From: Michael Eastham <Michael.Eastham@arun.gov.uk>
Sent: 30 April 2021 11:52
To: Planning.Responses <Planning.Responses@arun.gov.uk>
Subject: FW: Re: *EXTERNAL: RE: Felpham - FP/248/20/PL

Please upload onto Ocella the email below which is a response **from the applicant to ADC Neighbourhood Services** regarding planning application **FP/248/20/PL**.

Changing facilities:

TYPICAL CROSS SECTION THROUGH TARMAC/GRAVEL AREAS
Scale 1:20

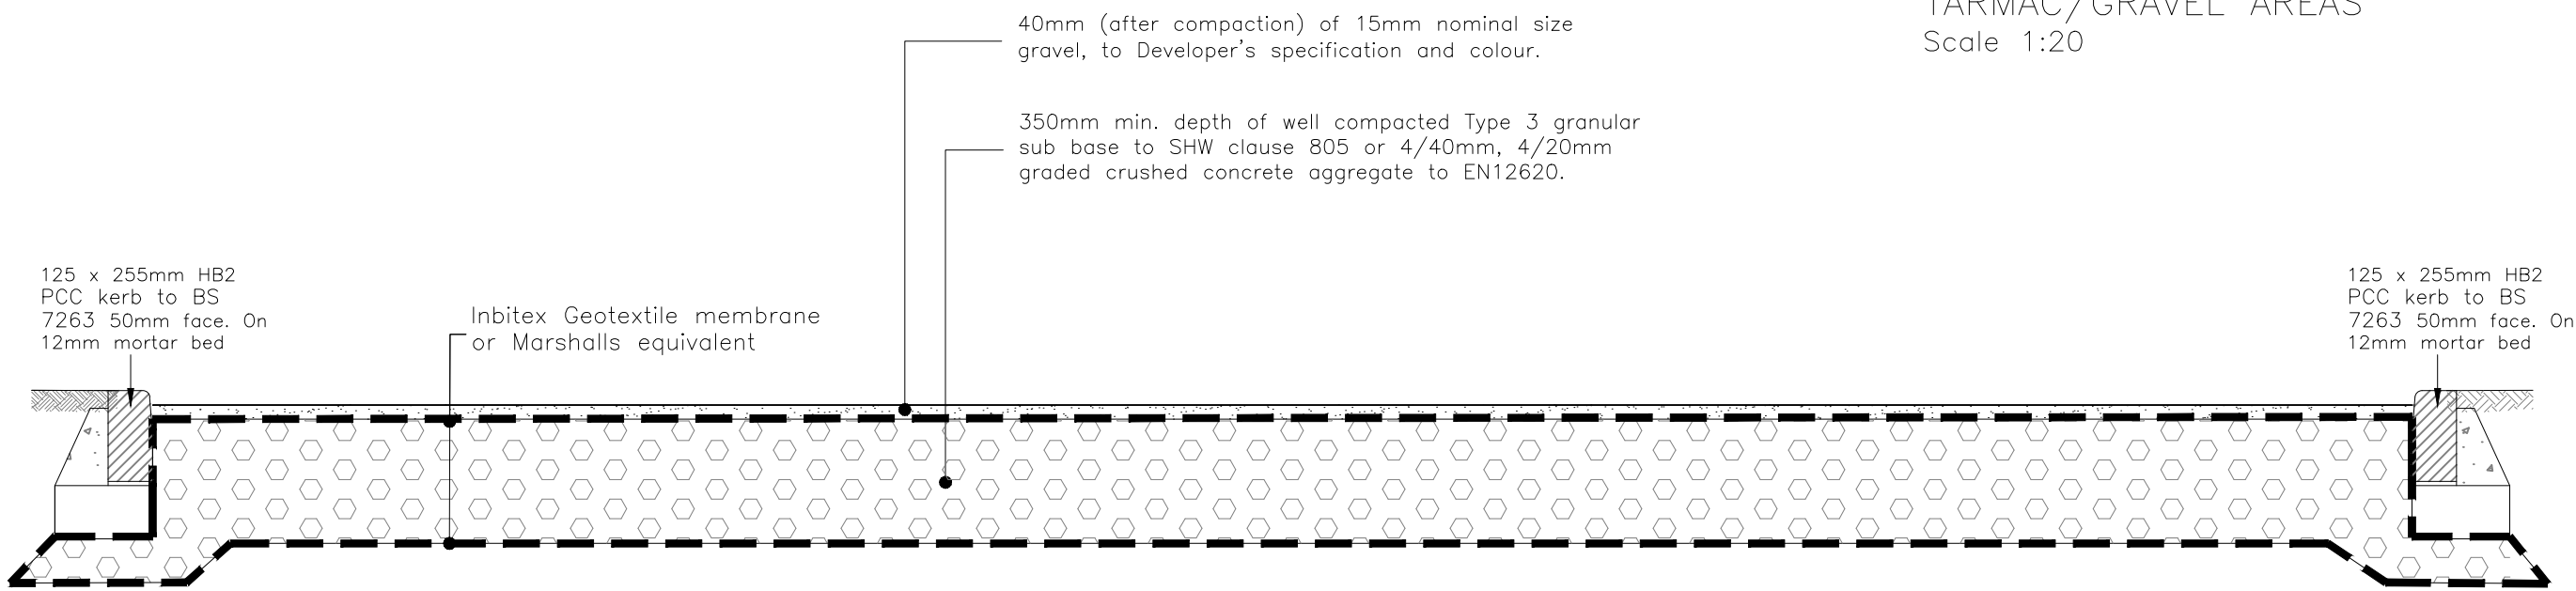
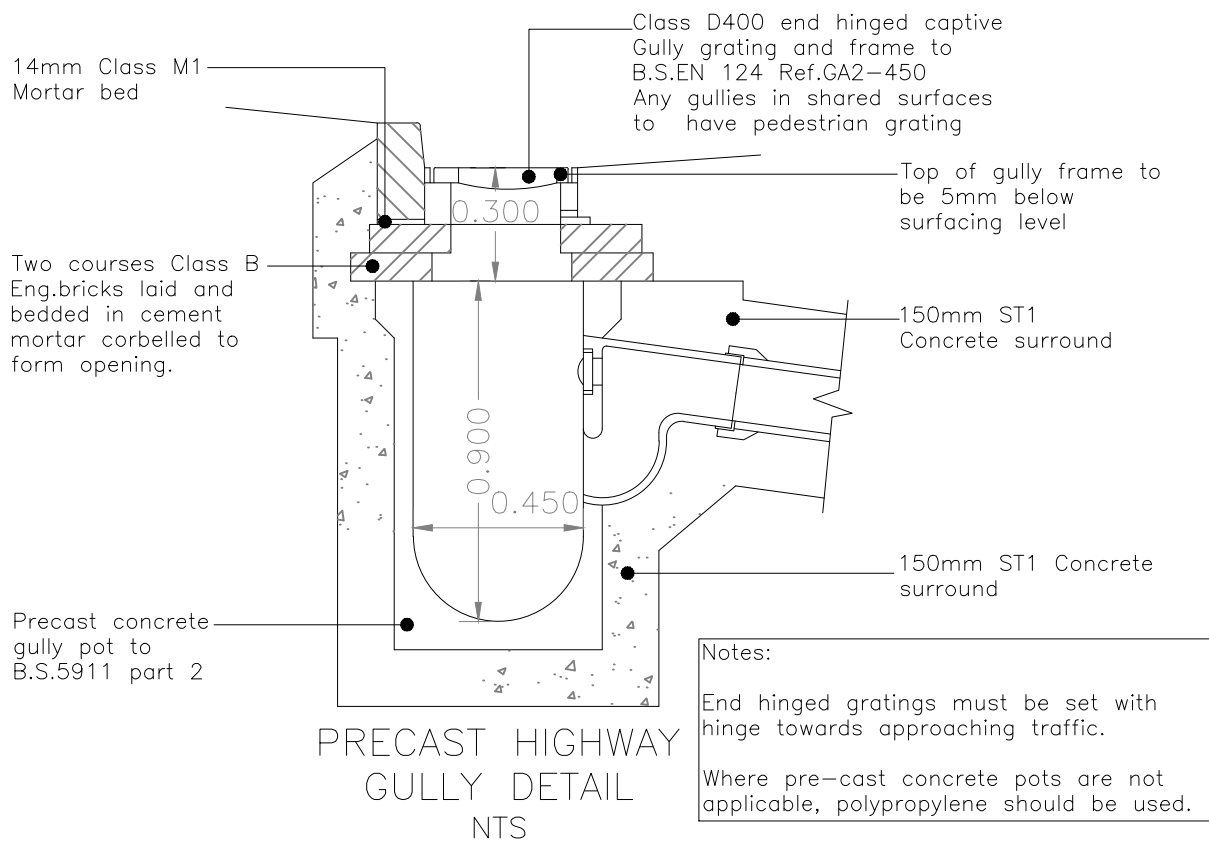
- Detail drawings to illustrate the fencing and the provision of a security gate and height barrier for approval is required.
- Specification of all tarmac surfacing, including sectional drawings and drainage must be provided for approval. – note the car park area proposed as gravel surfacing – this is acceptable if includes an approved grid system – confirmation required

client: Barratt Homes
drawing: Hard and Soft
Landscape Proposals

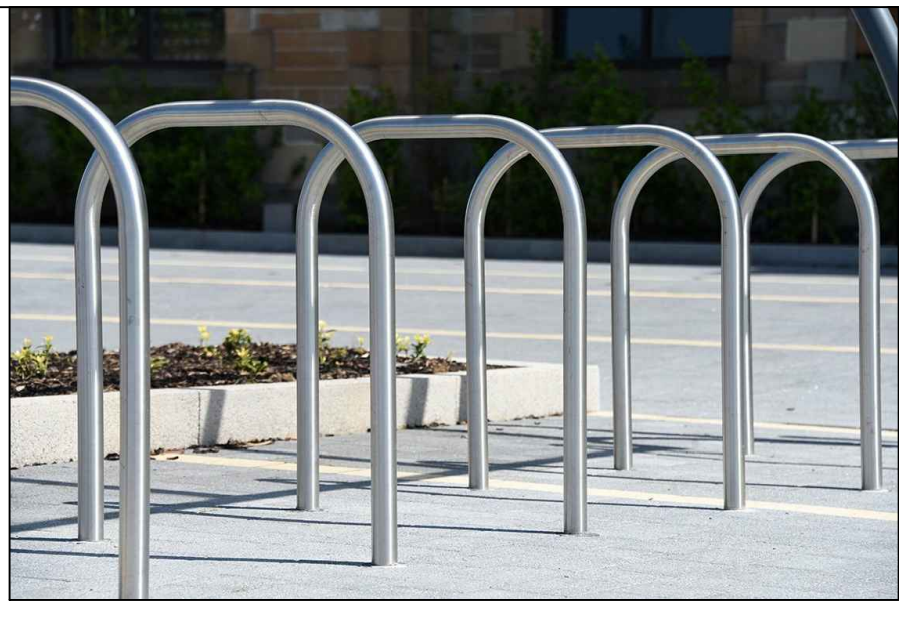
- There is no reference to the boundary fencing detail for large parts of the site – this must be provided. The site boundary must be clearly established on the ground in all areas. – details required - condition

- Provision of site furniture such as seating, bins and dog bins to be provided on site – detail and locations to be approved.
- Drawing needs to identify existing native planting to relief road boundary – on the noise bund and either side of the acoustic fencing.

- Details of tree / hedge planting is required – further planting opportunities should be demonstrated, particularly on site boundaries – species is not identified – this must be provided for approval.
